Charlotte Department of Transportation

Memorandum

Subject: Rezoning Petition 08-068: Located on the northeast corner of Eastfield Road and Highland Creek Parkway
(Revised 4/18/08)

RZ-1

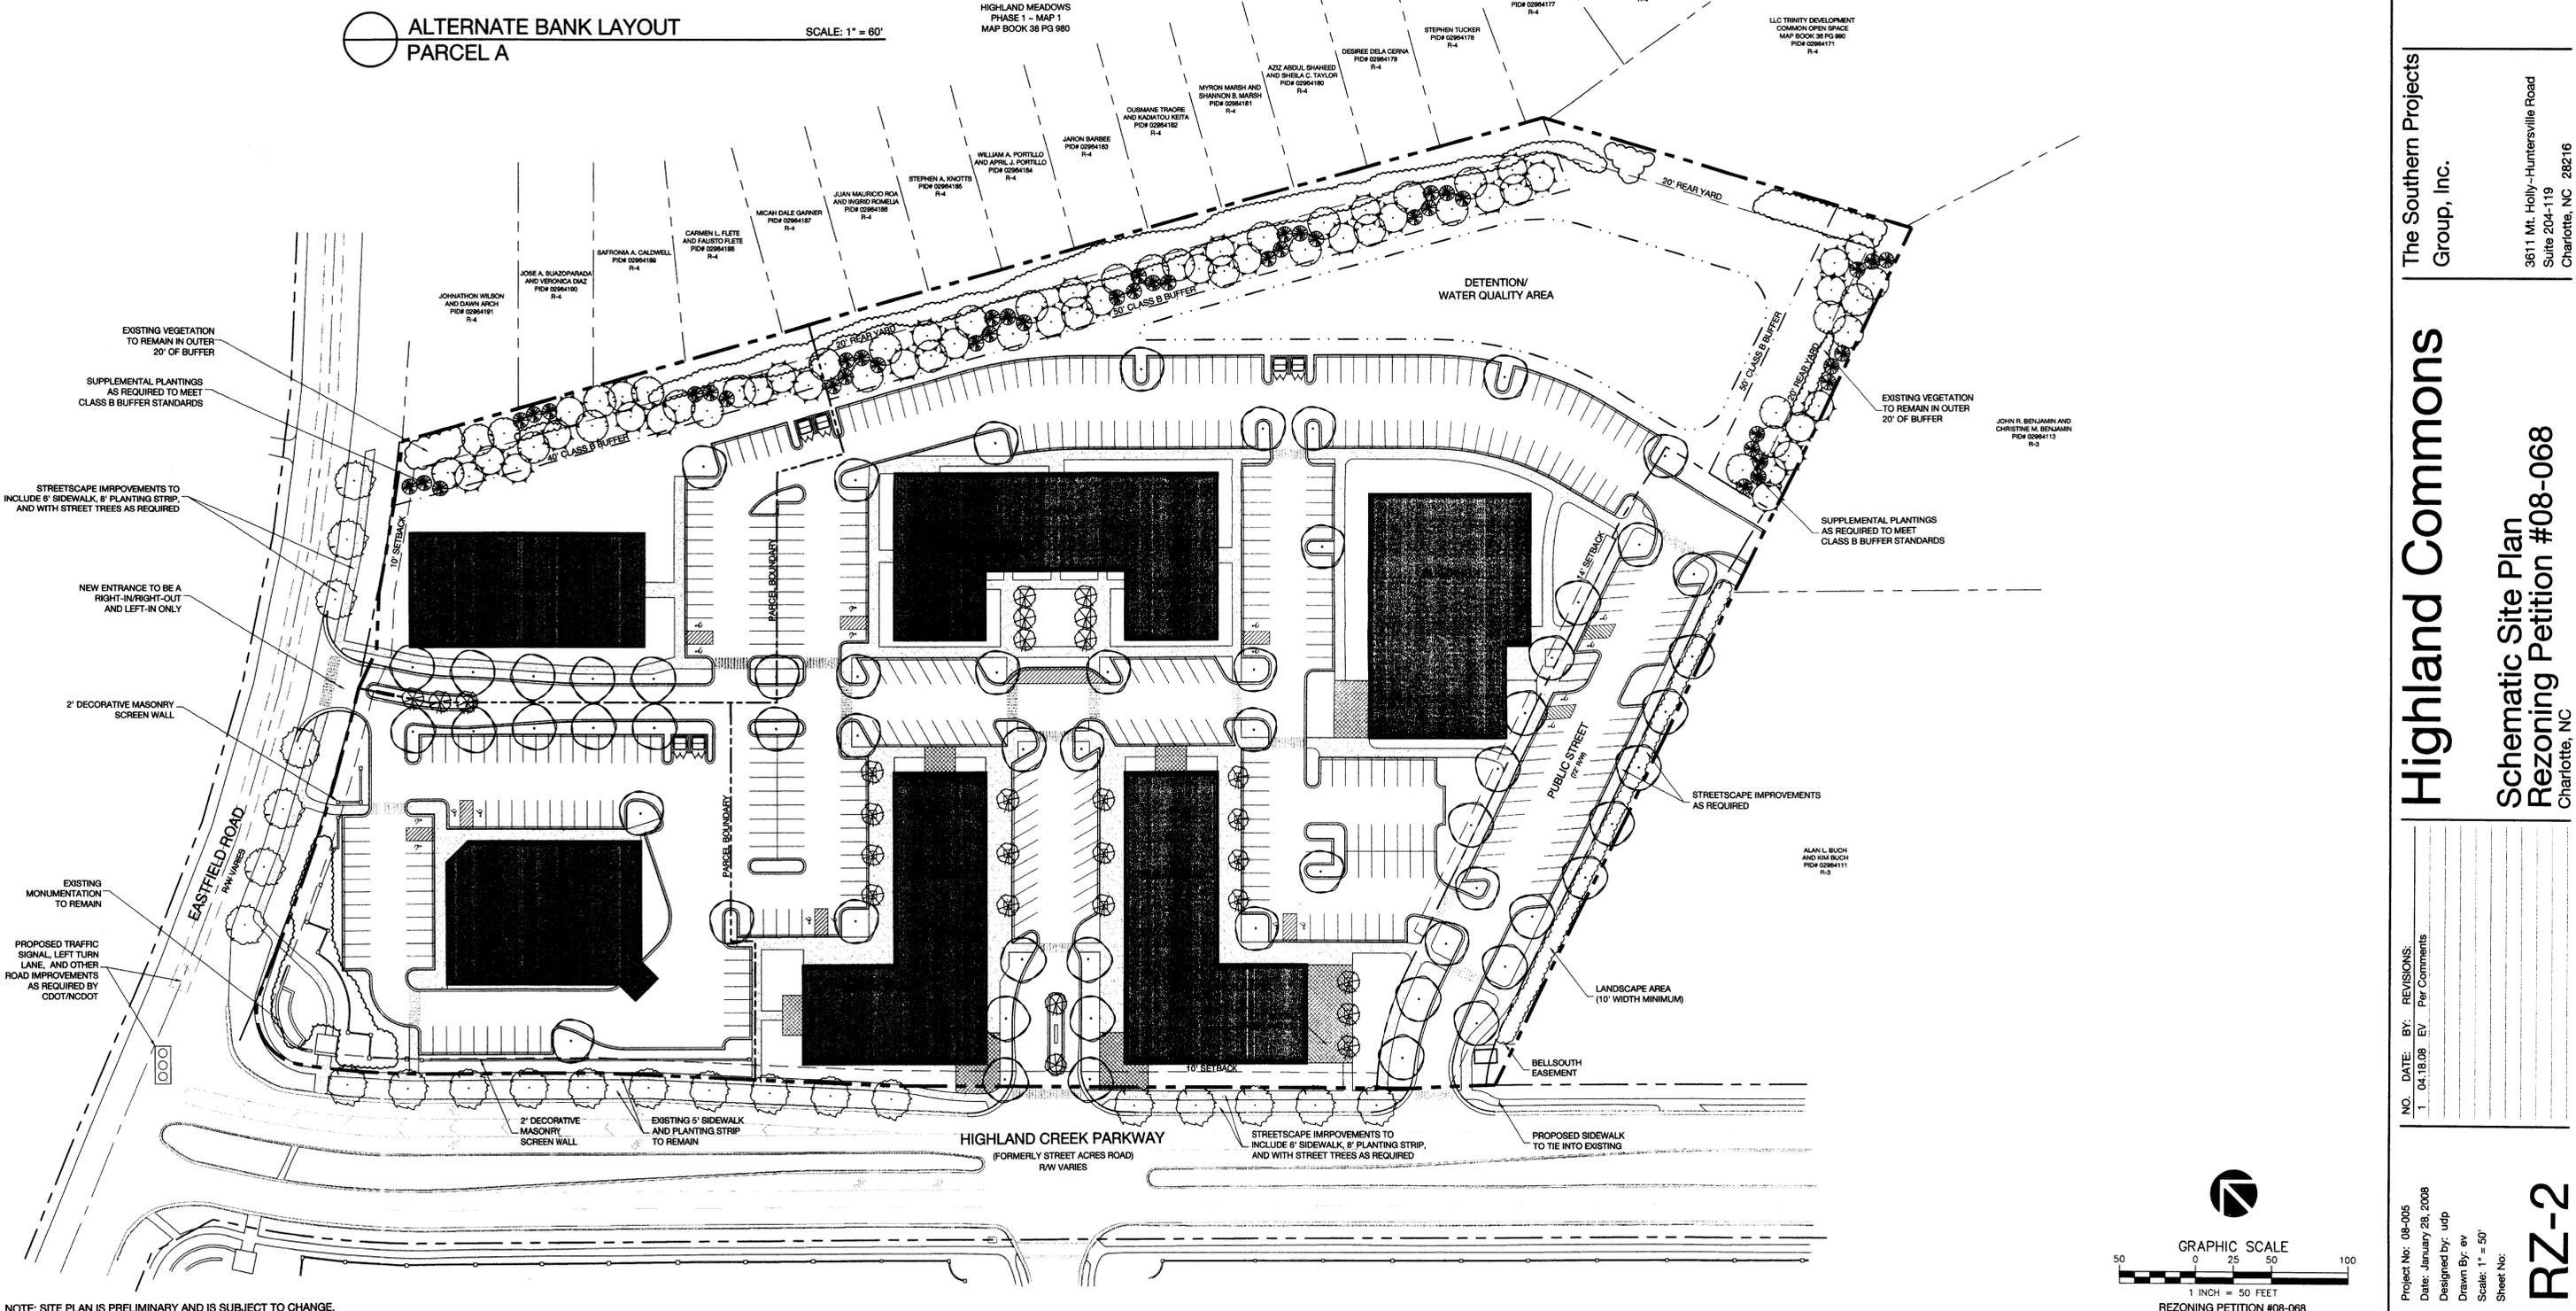
1. The proposed driveway to Eastfield Road needs to be deleted. Although the existing zoning

conditional site plan may not prohibit a driveway in this location, as stated in our March 28th memorandum, the NCDOT will not permit a driveway/access in this location.

5. Although staff and the petitioner have met to discuss the new public street identified in our March 28th review comments, the location of the proposed public street is not acceptable. As shown, the street is not designed appropriately for a future connection to the adjacent property and more importantly, it is not in a location for reasonable public use. Further, the location encourages vehicles to travel through the development's parking lots/aisles to reach the main entrance's full access opposite Falconcrest Drive at Highland Creek Parkway. The new public street needs to be located opposite Falconcrest Drive and stub to parcel #029-641-13 as indicated in our previous comments.

PUBLIC STREET CROSS SECTION C-C' SCALE: NTS

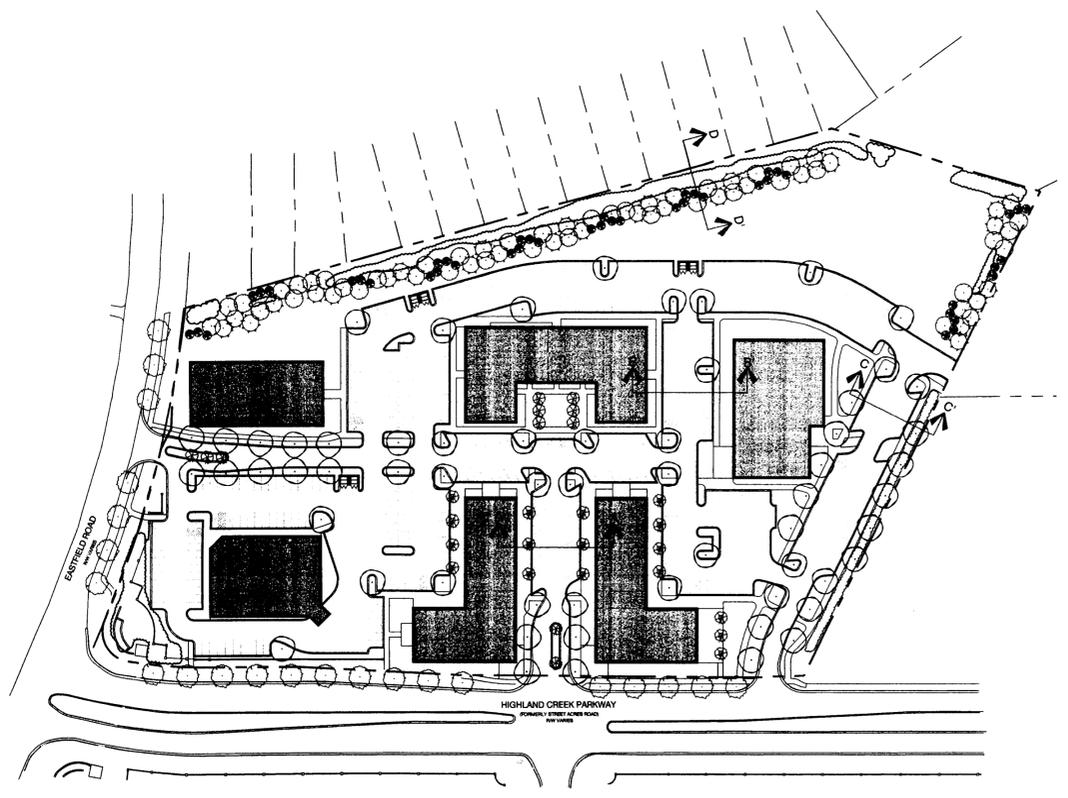
6. The new public street needs to be constructed as an Office/Commercial-Wide street with a 41' width (back of curbs), 8' planting strips, and 6' sidewalks in accordance with the adopted Urban Street Design Guidelines. This street width accommodates parallel on-street parking.

7. Parking on the new public street cannot begin within 100 feet of Highland Creek Parkway or within 20 feet of the end of the corner radius of any intersecting street or driveway.
